# City of Albuquerque Stormwater Construction Site Inspection Report

ESC File No.	H17E097	Project Name:	Carlisle Crossing		
NPDES Id. No.	NMR10040K NMR10040H	Location:	2100 Carlisle Blvd. NE		
10/21/2021	Owner	Contractor			
Operator	Carlisle Associates LP	Jaynes Corp.			
Contact name & title	Dave Rosen C/O Joe Bernabeo	Jesus Ortiz			
e-mail	<a href="mailto:jbernabeo@rosenmgmt">jbernabeo@rosenmgmt</a>	<a href="mailto:jesus.ortiz@jaynescorp.com">jesus.ortiz@jaynescorp.com</a>			
Contact Phone #	505-304-4516	505-345-8591			
COA Inspector	Doug Hughes	Start/End Time:	10:30 AM		
Construction Phase:	Excavation/grading				
Type of Inspection:	Regular	Storm Event	Past Storm Event >0.25"	311/Complaint	Follow Up
Weather at time of inspection?		clear	Temperature: ~		73
Estimated date of last storm 0.25" or greater		n/a

TEMPORARY DETENTION POND  DEMOLITION

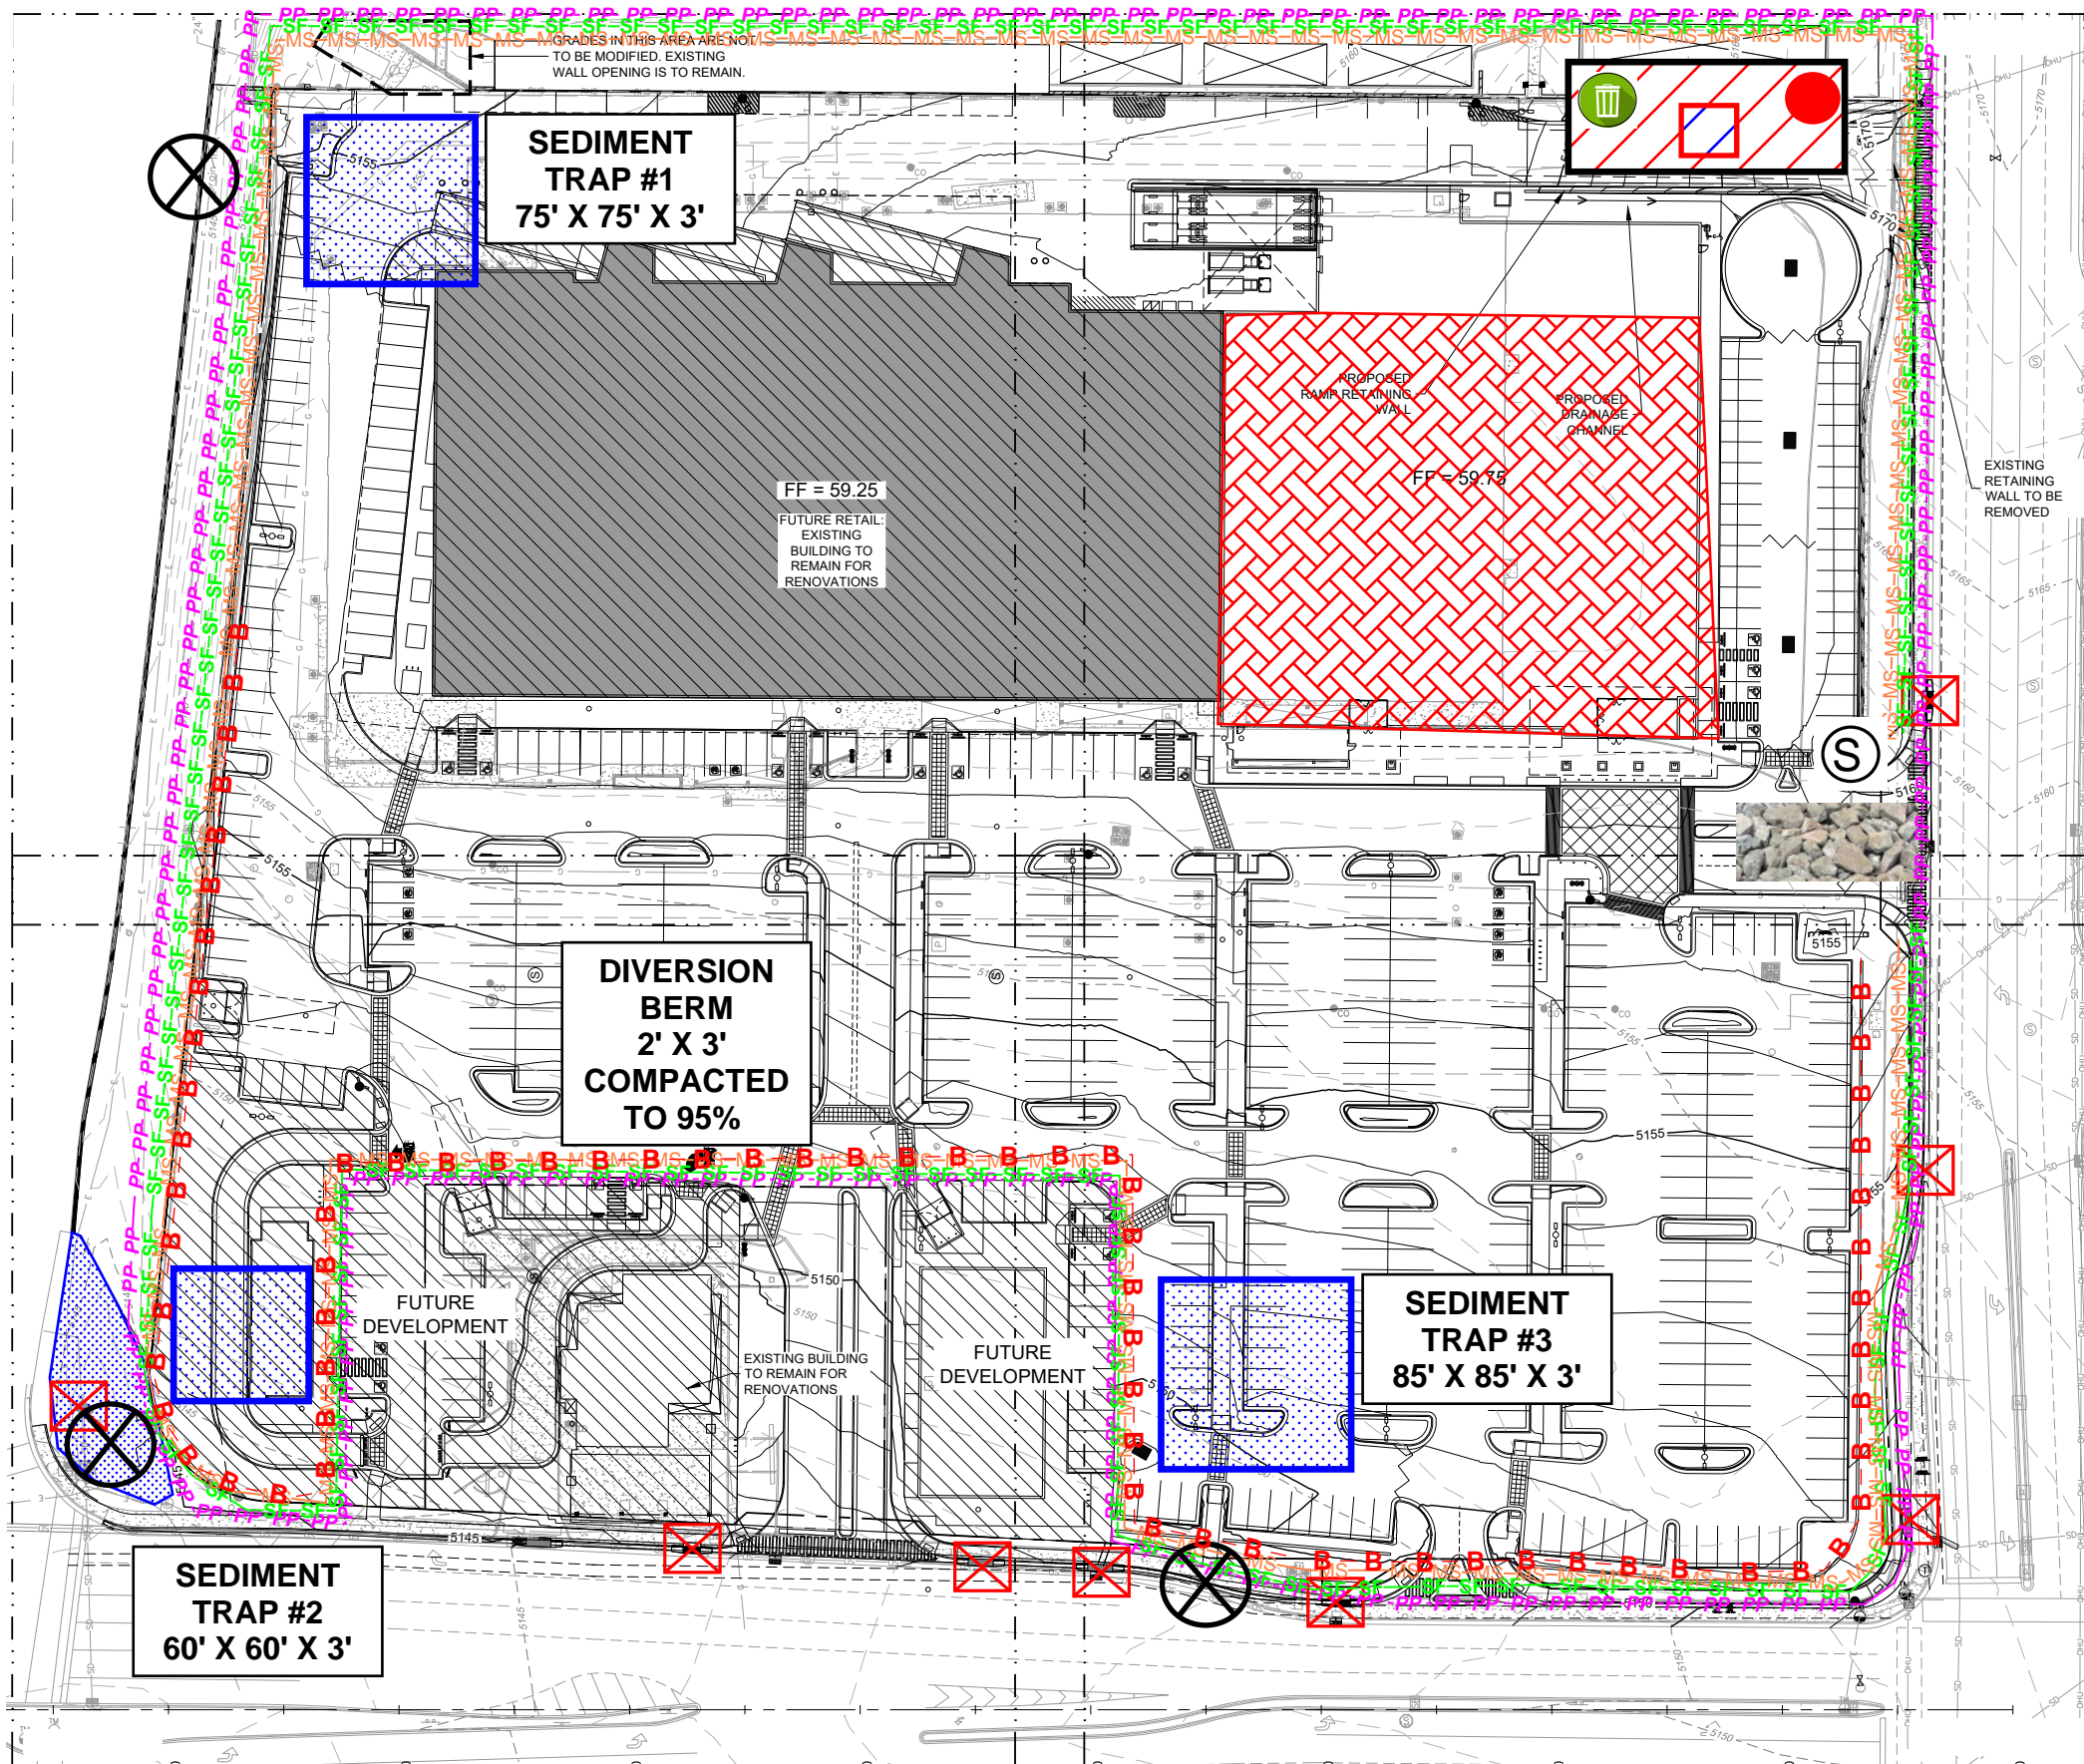
Item Number	Deficiency/ Corrective Action				
1	BMPs are missing in the northeast corner. BMPs will also be needed for impending Work Order.				
2	SWPPP is not up-to-date. Map out of date in the northeast corner and doesn't reflect the recently approved G&D Plan. BMPs must be added for impending Work Order.				
3	Floatable trash in northeast corner must be disposed of in proper container.				
4					
5					
6
